APPLICATION NO: M/51/18/PL

Site Address: 5A Tuscan Avenue and 6 Main Drive Middleton-On-Sea PO22 7TE

Description of Works: Demolition of properties and construction of 1No new building comprising 1No 3bed and 1No 1bed properties.

WEST SUSSEX COUNTY COUNCIL CONSULTATION

5A TUSCAN AVENUE & 6 MAIN DRIVE, MIDDLETON ON SEA
PROPOSED GROUND AND EXTERNAL LAYOUT/TOPOGRAPHIC SURVEY

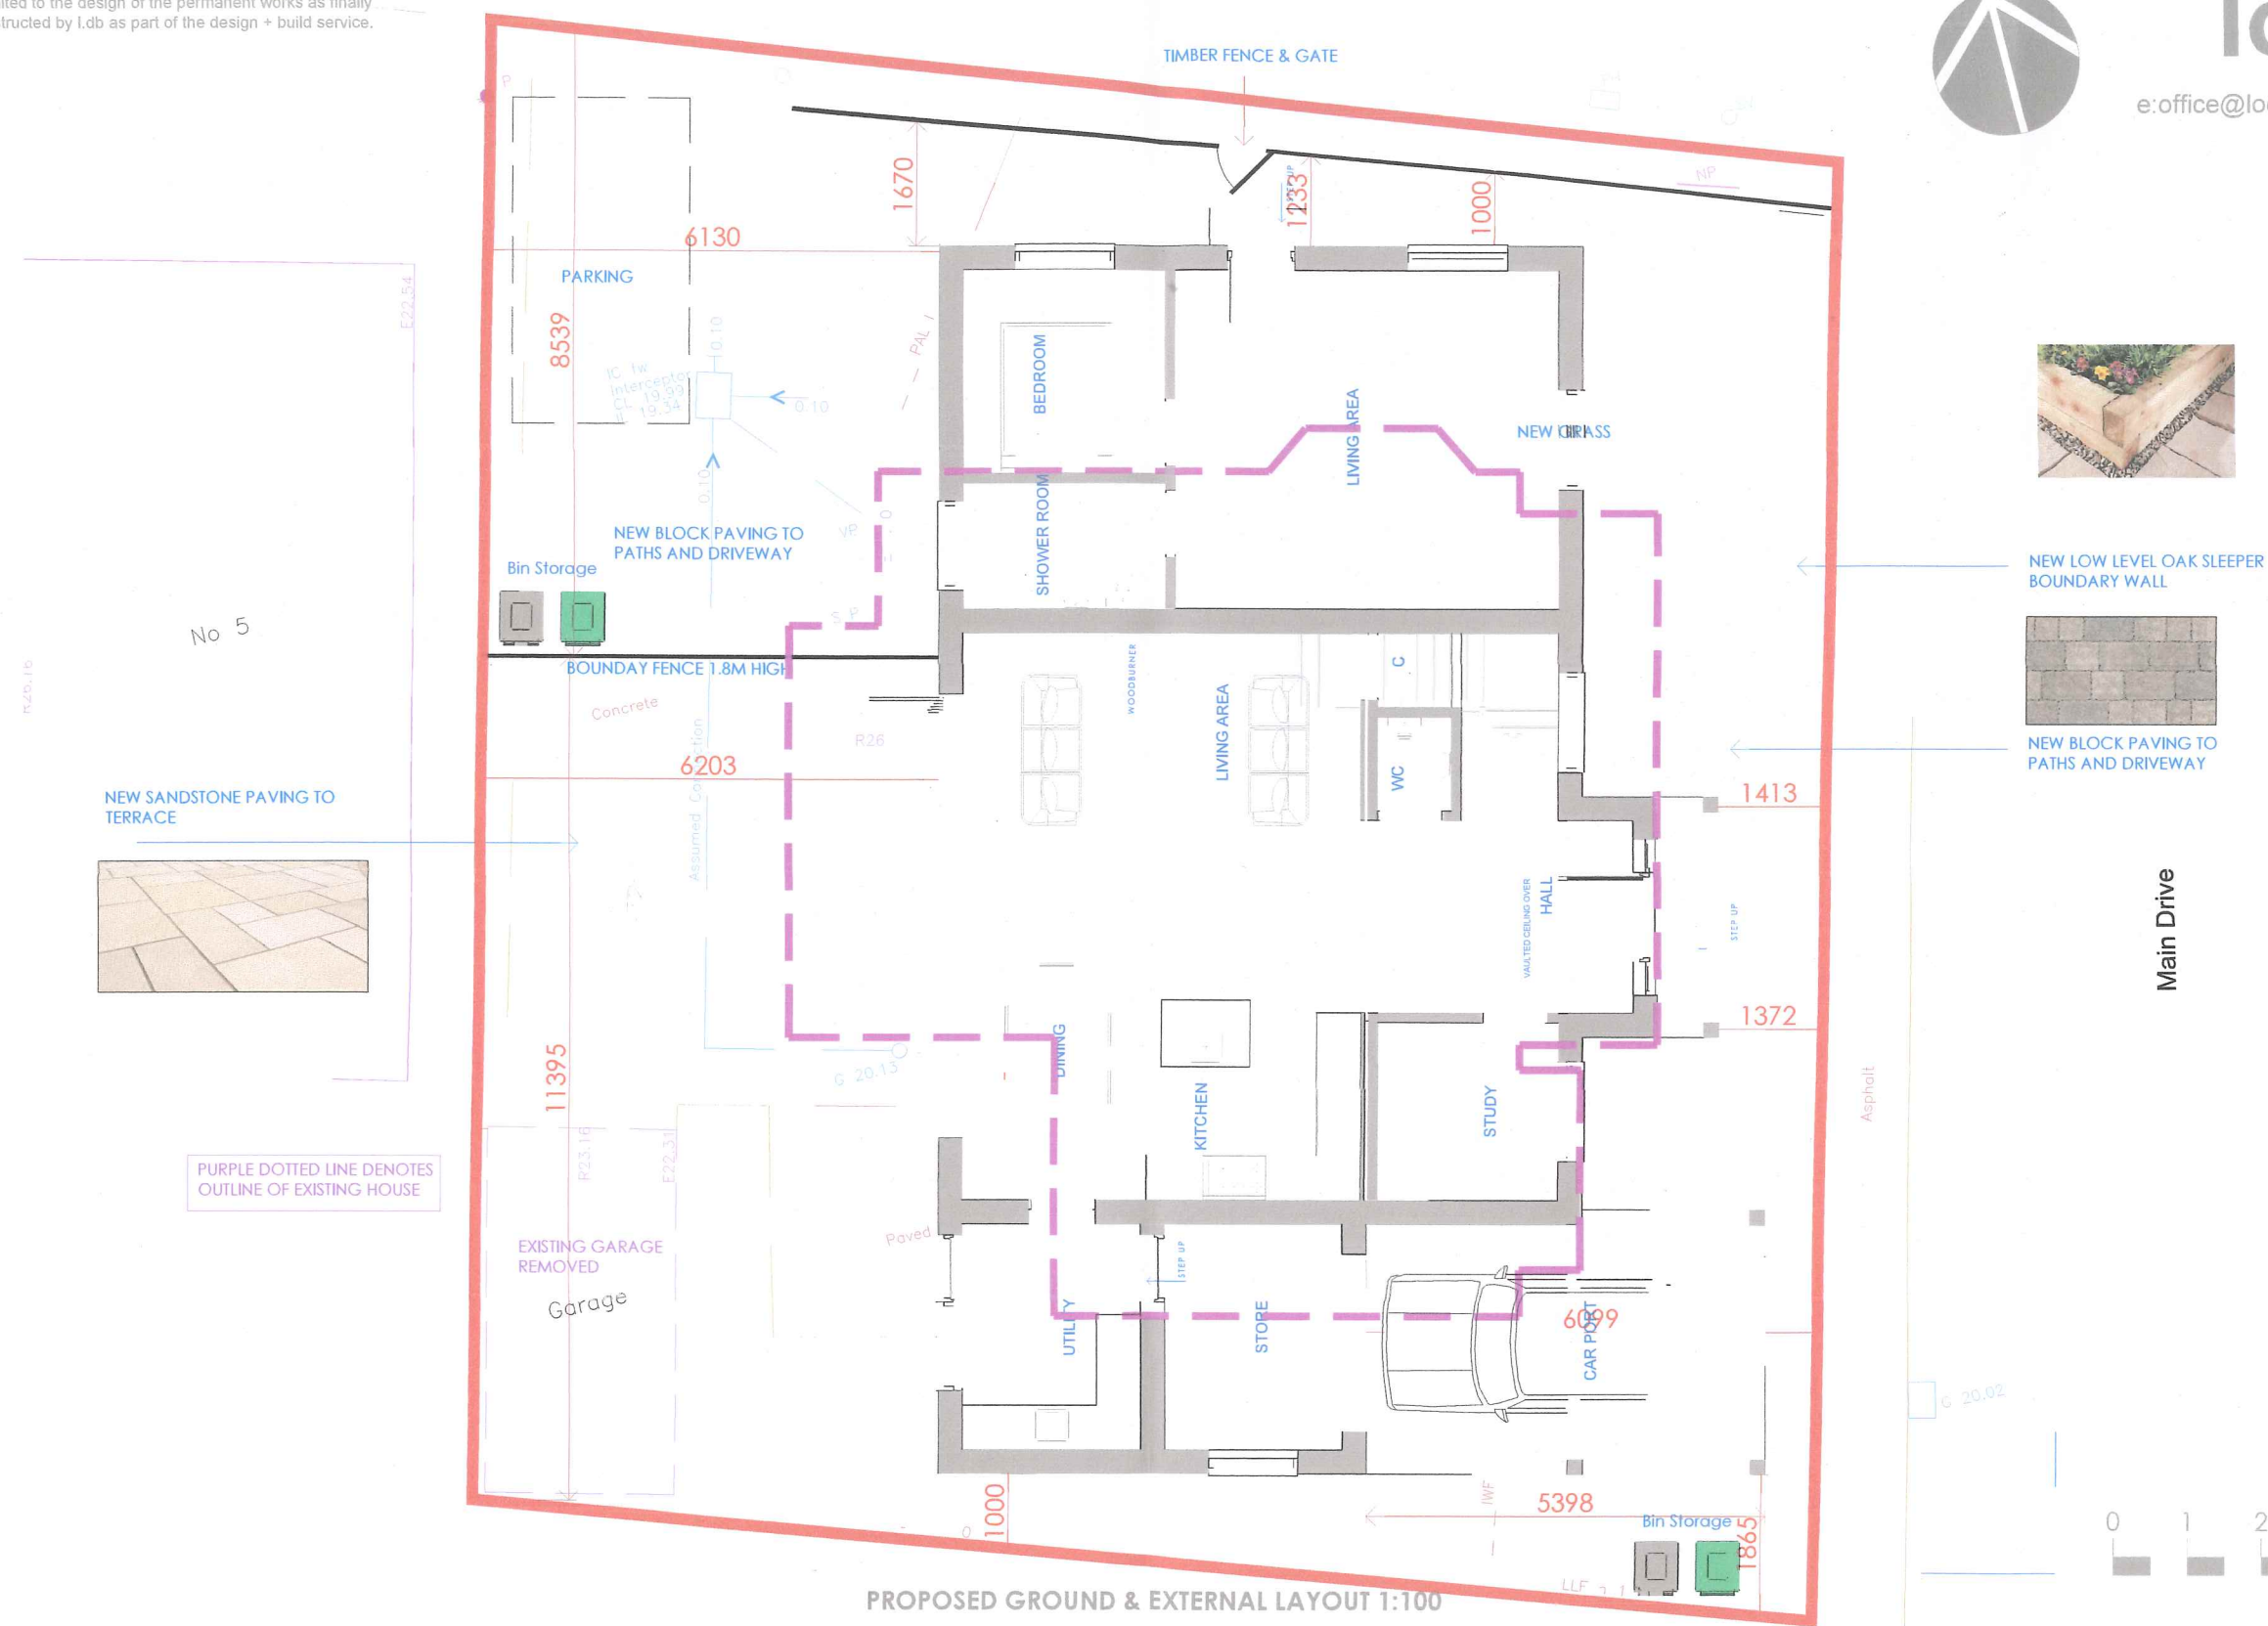
The proposed plans indicate that the access from Tuscan Avenue will be retained to serve the one bedroom dwelling and an additional access will be created from Main Drive to serve the three bedroom dwelling. The applicant is advised to contact the proprietor of the private road(s) to obtain formal approval for any access works.

The plans propose that the existing garage will be demolished and a total of 2 parking spaces will be provided for the development, one space allocated to each dwelling. The WSCC car parking demand calculator anticipates that a minimum of three parking spaces will be required for a development of this size and location. The applicant may wish to consider providing a third parking space on-site to meet the anticipated demand. However, overspill parking could be accommodated on Main Drive and is not anticipated to cause a highway safety concern.

From an inspection of the plans, the proposed parking space for 5a Tuscan Drive does not meet the required minimum specifications of 2.4 x 4.8m as set out in Manual for Streets (MfS). Plans do not clearly demonstrate the size of the proposed car port and associated parking space, which should also meet minimum specifications of 2.4 x 4.8m. Details of this can be secured via condition.

No part of the development shall be first occupied until the car parking spaces have been constructed in accordance with plans and details to be submitted to and approved in writing by the Local Planning Authority. These spaces shall thereafter be retained at all times for their designated use.
